AL/7/21/L

The Long House Nyton Road Westergate PO20 3UP

Listed building consent to replace the tiles on roof, remove a small dormer on rear elevation & replace with a conservation style rooflight & add an identical rooflight.

THE LONG HOUSE NYTON ROAD EASTERGATE
ROOF PLAN PROPOSED
FRONT

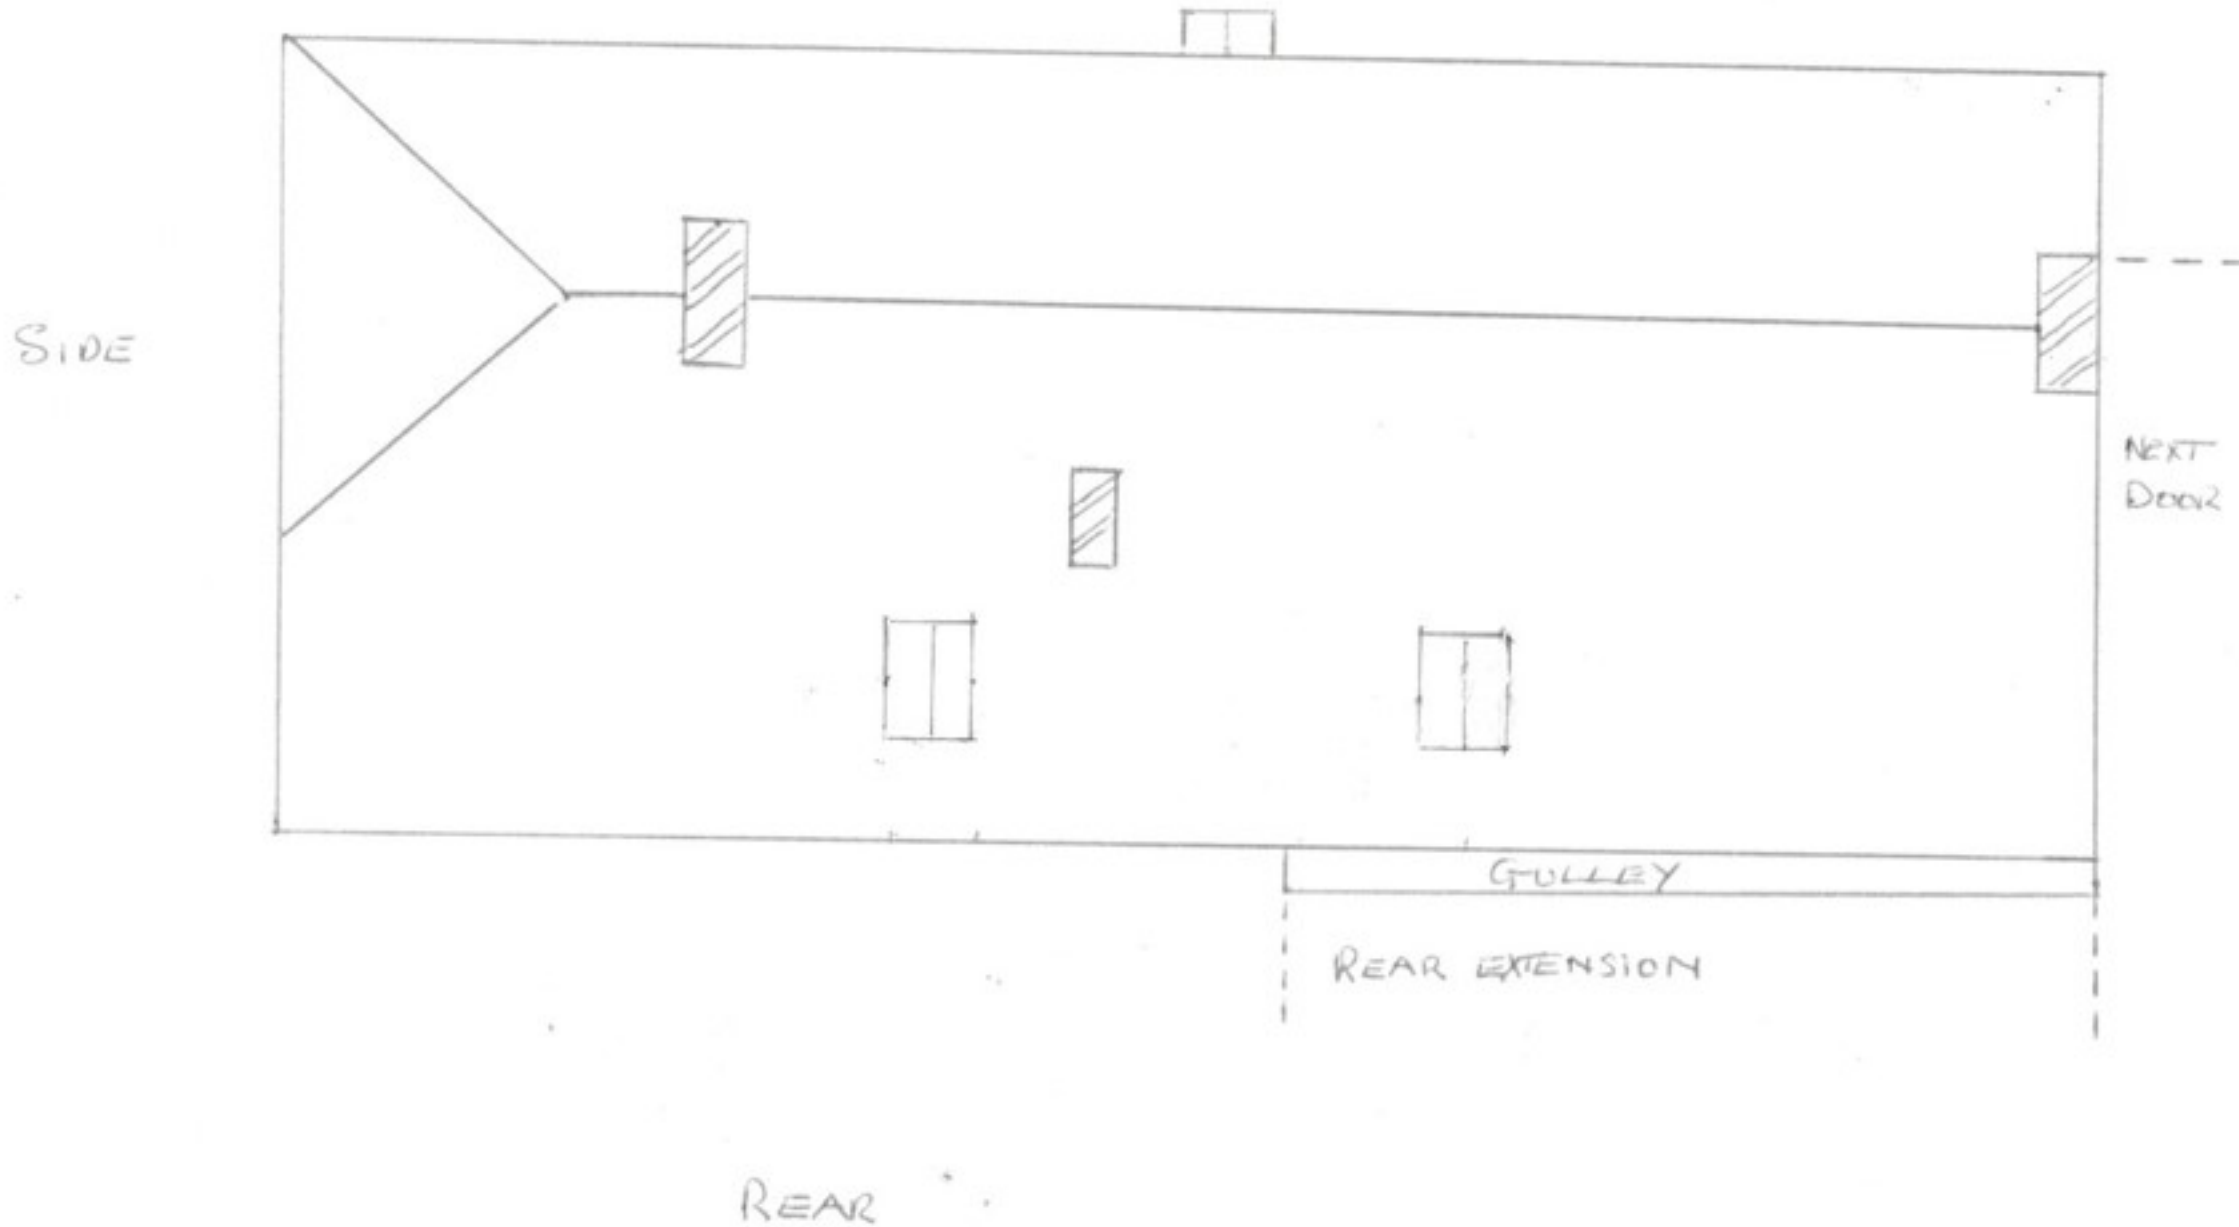
The proposal is to replace the tiles on the roof, remove small dormer on rear elevation and replace it with a conservation style rooflight. A further rooflight is proposed on the same elevation in order to provide for more ventilation into one of the bedrooms.

Whilst the complete replacement of the tiles on a listed building would be carefully considered, it is noted that the heritage statement identifies that the existing ones have been harmed through the use of inappropriate foam insulation. This is unfortunate as it has resulted in unnecessary damage to historic fabric. The complete replacement of the tiles is therefore acceptable in this instance. However, the new tiles should match the existing ones in terms of size, appearance and

colour. Further, the height of the roof should also not change, with any new insulation being appropriate for the listed building. If minded to approve the application, you may wish to view a sample of the proposed tile in order to ensure that it matches the existing ones. This could be achieved by way of condition.

The loss of the dormer and its replacement with a rooflight will not harm historic fabric as this would appear to be a later addition to the building. Whilst the additional rooflight would result in the loss of a very limited amount of historic fabric, it will not cause harm. It is noted that the intention is for the rooflights to be of a conservation style and flush with the roof slope, which is positive. Further, it is noted that the intention is to return the rear elevation of the building to a more appropriate appearance. The location of the rooflights is also such that the conservation area will not be harmed.
